29 April 2016

**NOS. 80 – 88 REGENT STREET, REDFERN  
PROPOSED MIXED USE REDEVELOPMENT (SSD 7080)**

We have reviewed exhibited materials relating to the abovementioned application and make this submission on behalf of the proponent for the potential future redevelopment of Lots 1 – 3 DP 3954 and Lot 1 DP 184335, Nos. 90 – 96 Regent Street, Redfern.

Drawing Name
Elevations - North & South

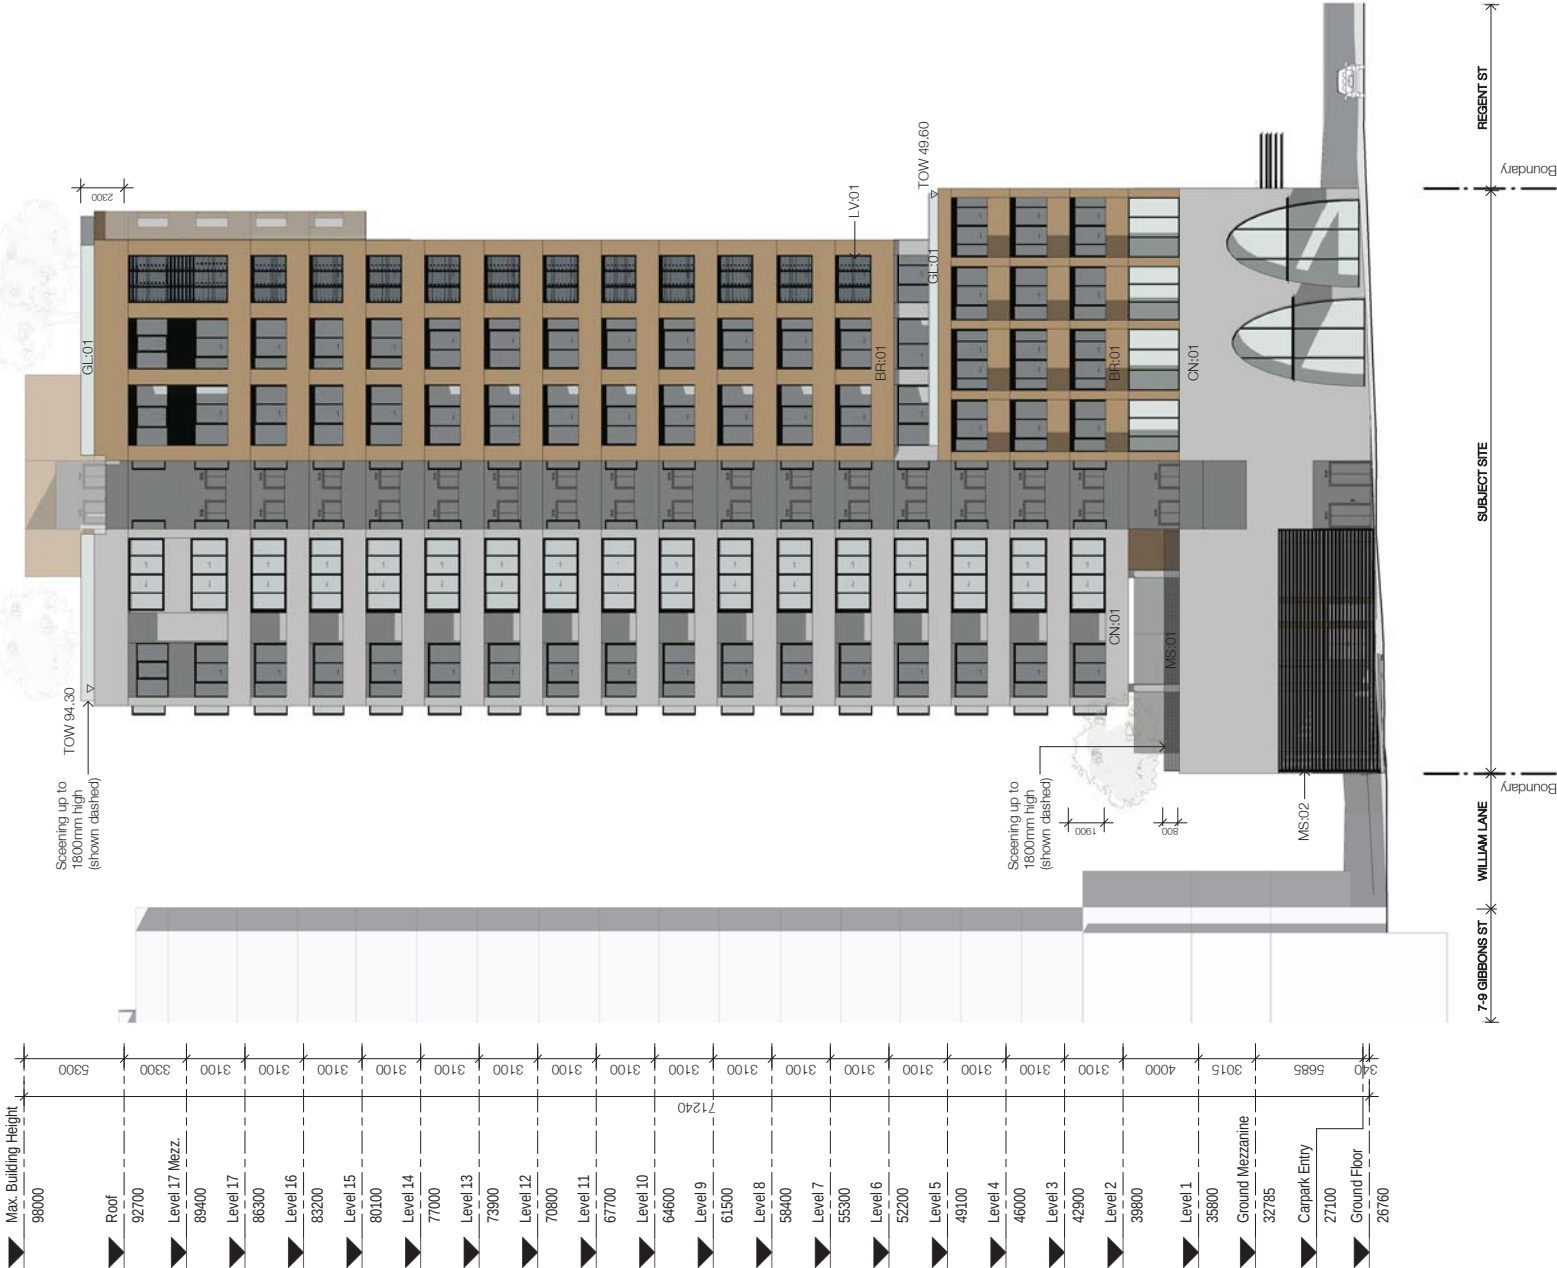
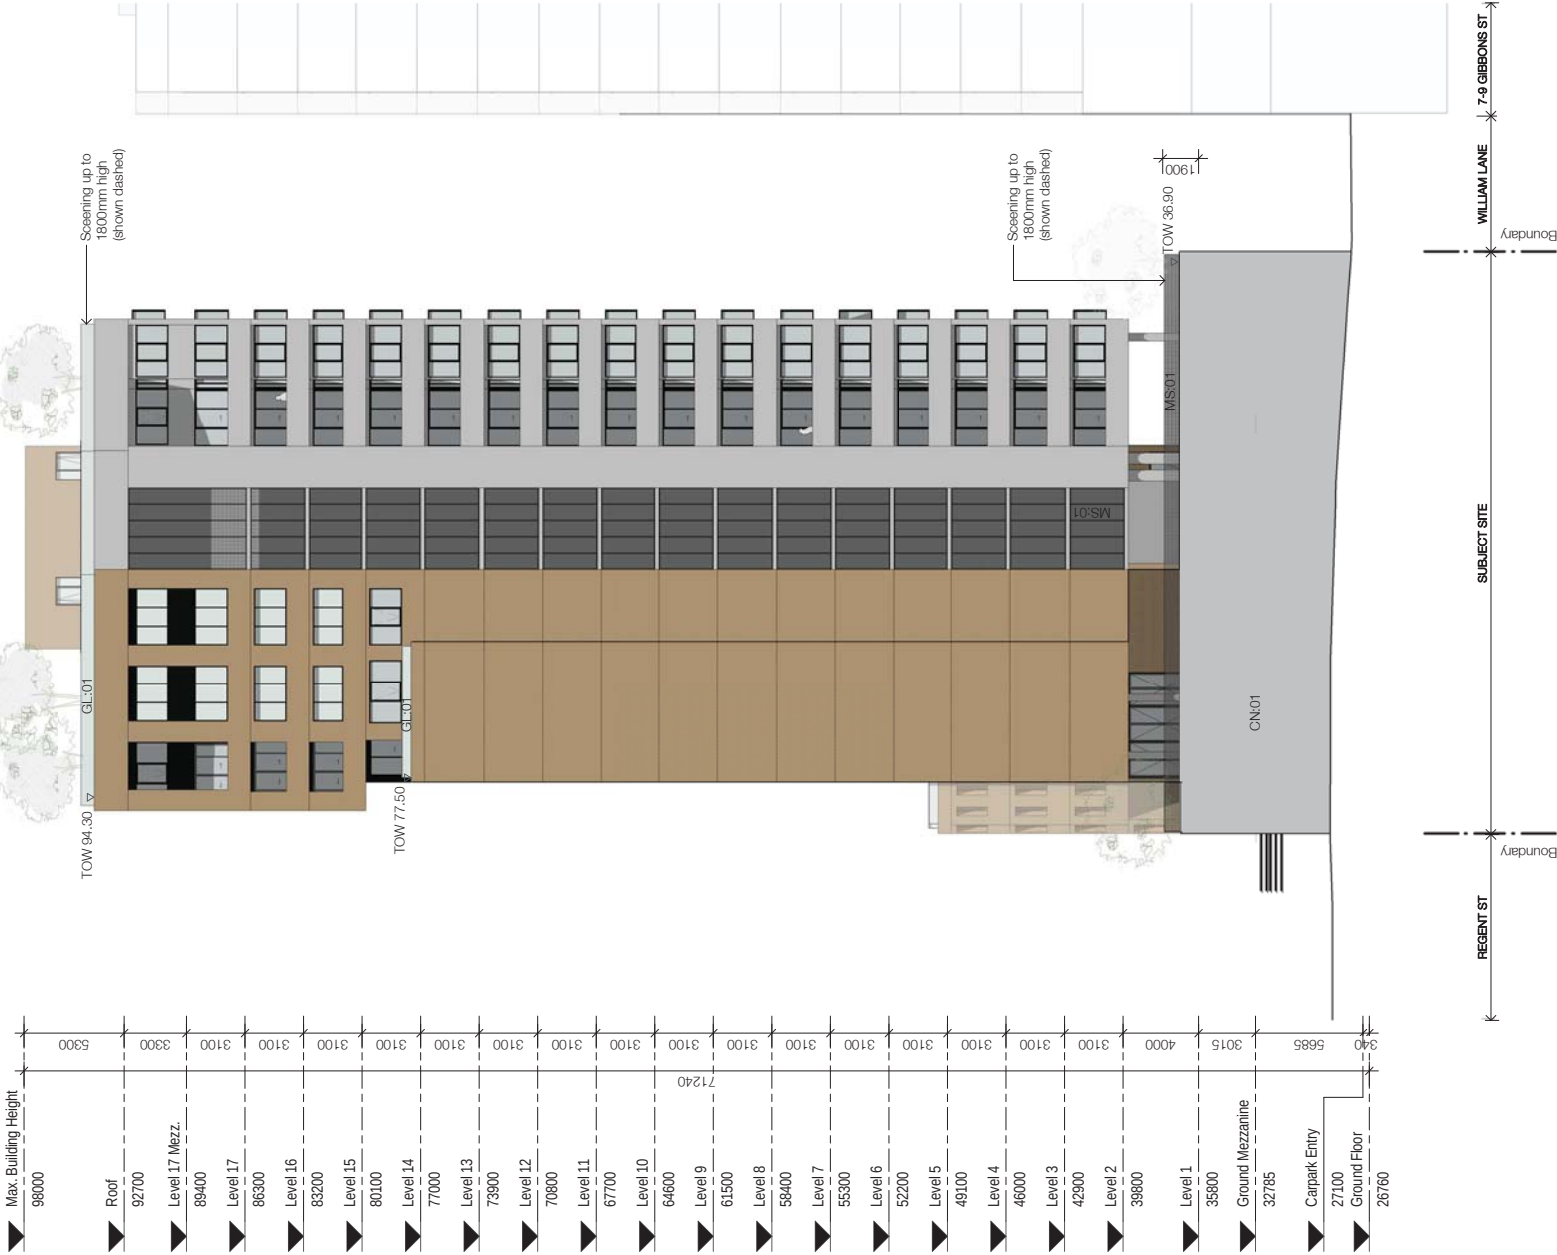
- Whilst the controls envisage an 18 storey building upon this site, owing to proposed mezzanine levels and rooftop plant, the proposed development presents as a 20/21 storey built form.

Job No. 5359 Drawing No. DA-0501 Revision / 11

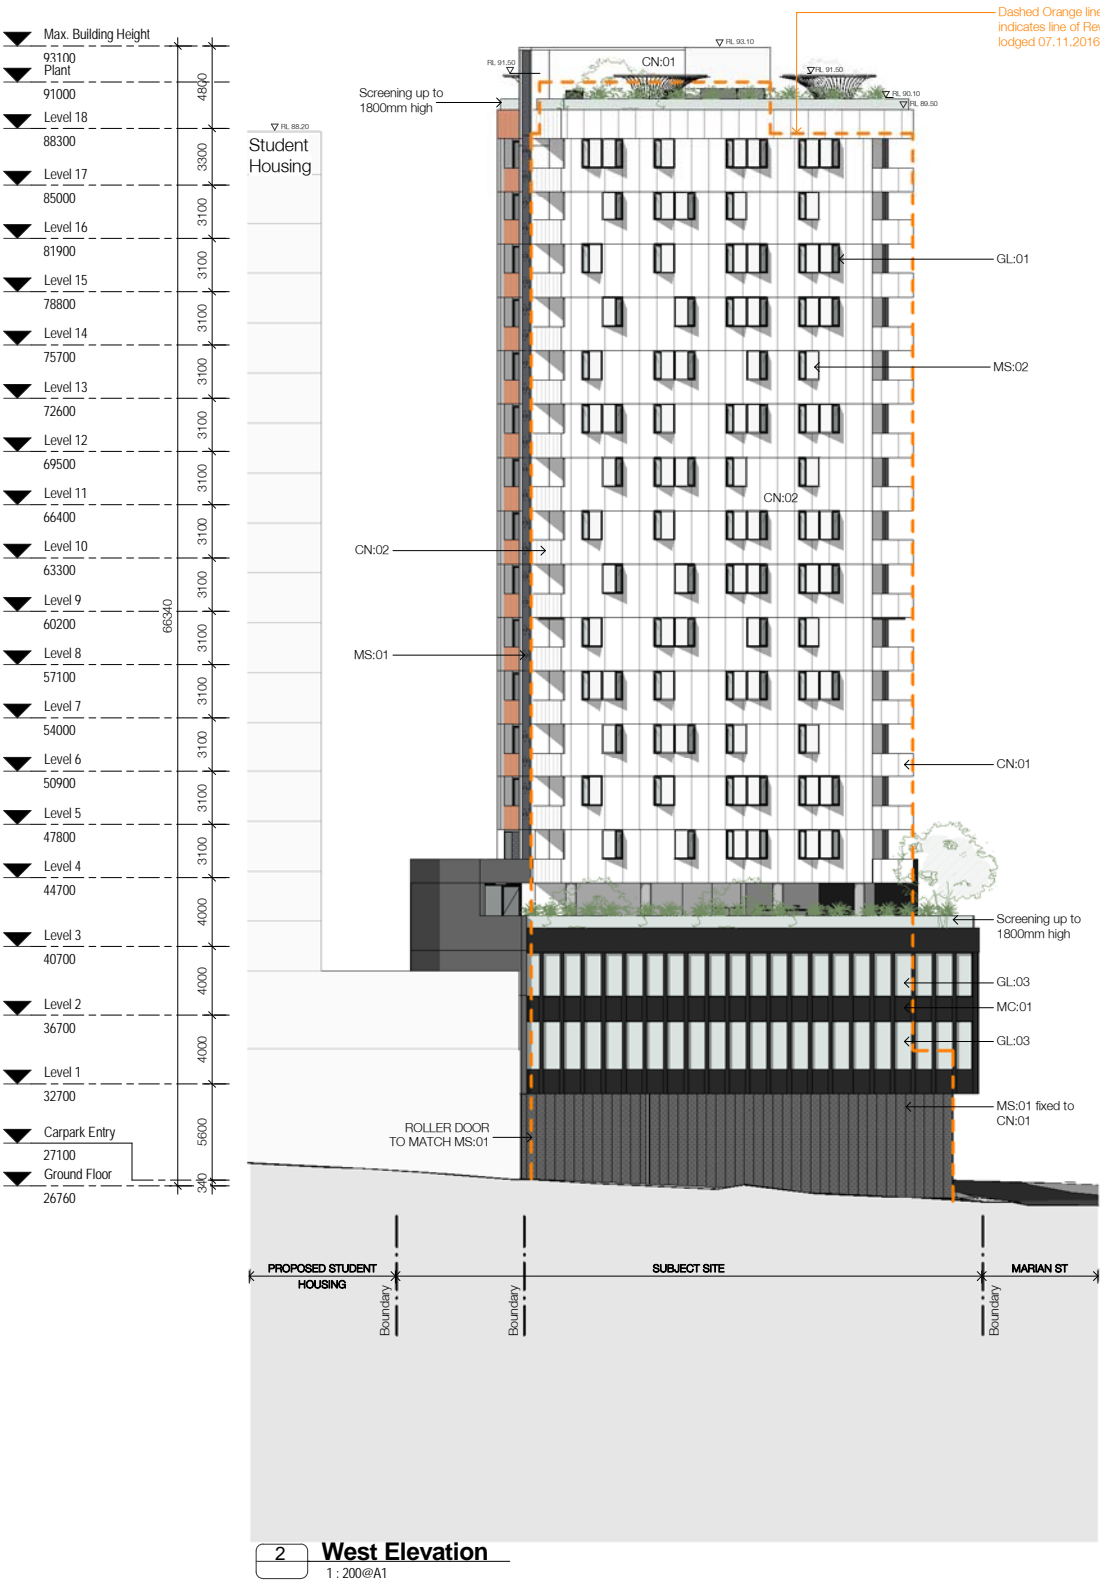
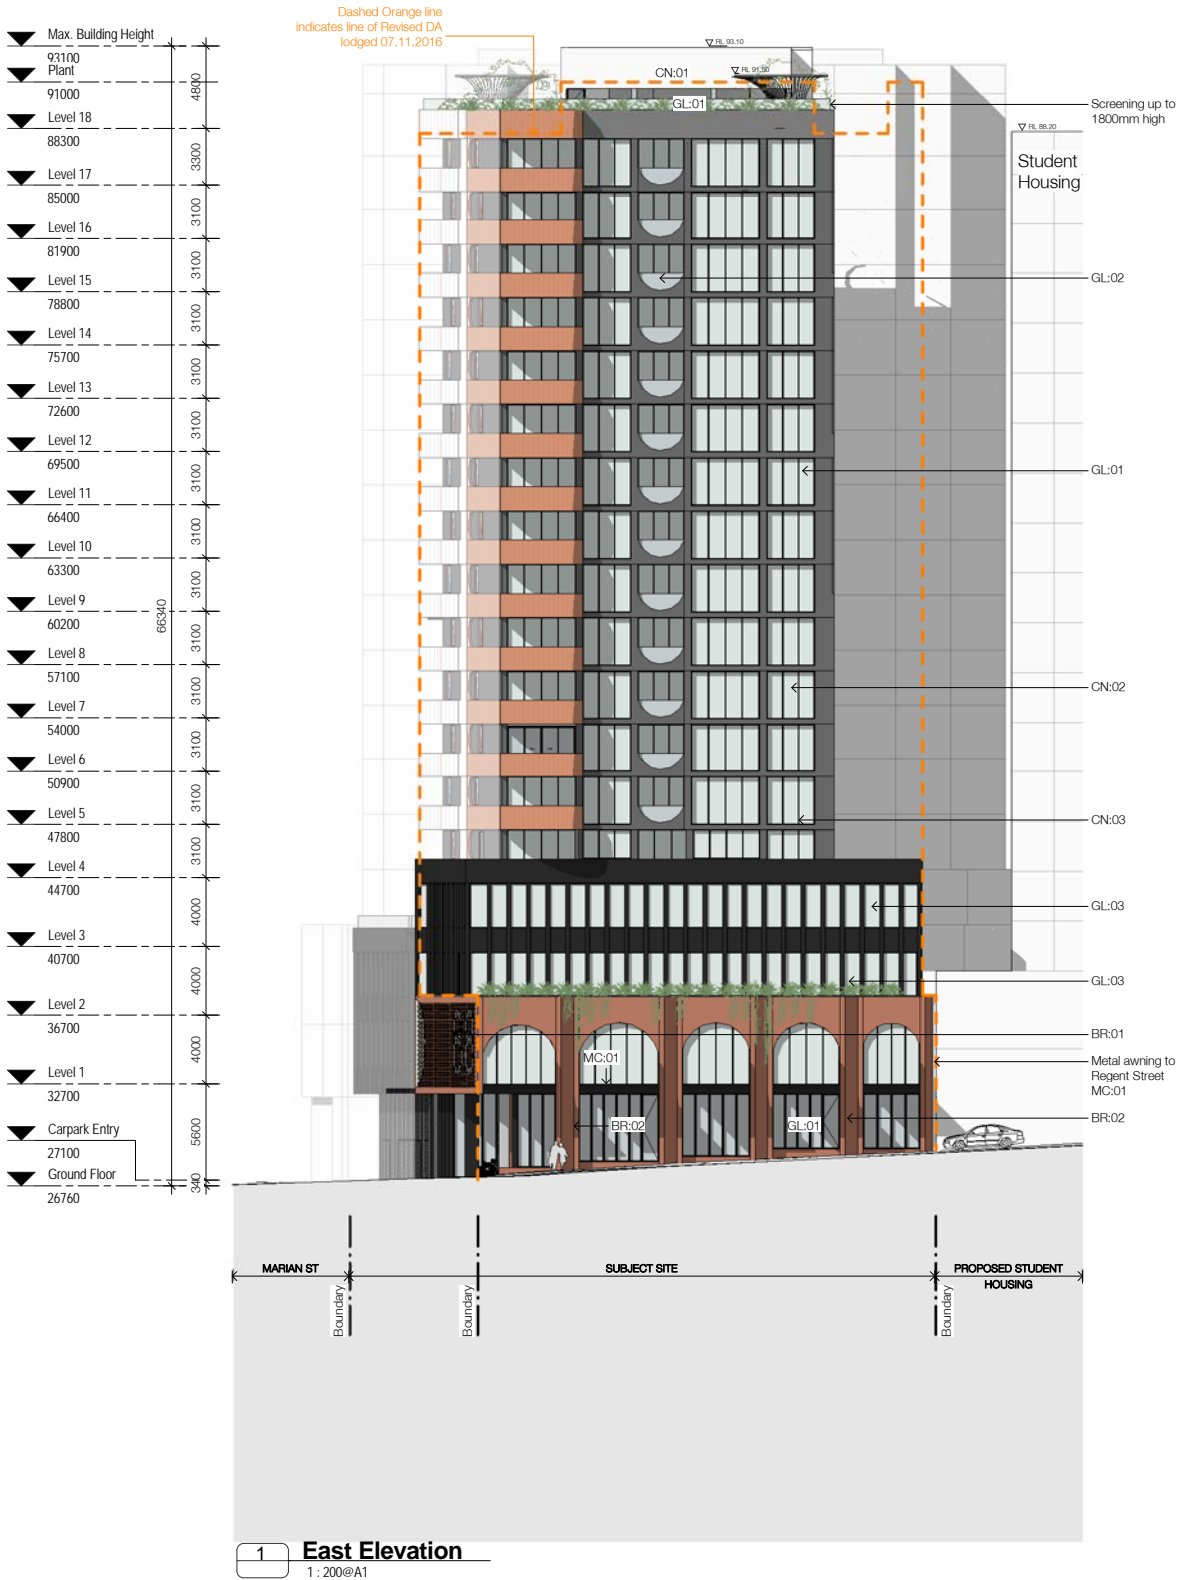
- It is noted that the completed development at Nos. 7 – 9 Gibbons Street has habitable rooms setback 4 metre from the original Marian Street alignment, consistent with the requirements of the Guidelines.
- Balconies and habitable rooms of the proposed development are currently within the 4 metre Marian Street setbacks prescribed by the Guidelines, and within the recommended separation distances espoused by the ADG.
- The reduced setbacks will compromise privacy and solar access for future development of Nos. 90 – 96 Regent Street.
- It is suggested the 4 metre setback above the podium level to Marian Street should be strictly enforced.

- The Guidelines prescribe an 8 metre setback for the tower element above Regent Street.
- It is noted the proposed development is setback between 0 – 3 metres.
- It is noted the approved alignment of development at Nos. 60 – 78 Regent Street ranges between 3 – 4.5 metres and that the proposed development is generally consistent with these setbacks.
- It would be expected that for the purpose of creating a consistent street edge, that any setback supported for this development would be applied as an appropriate precedent to any future development of Nos. 90 – 96 Regent Street.
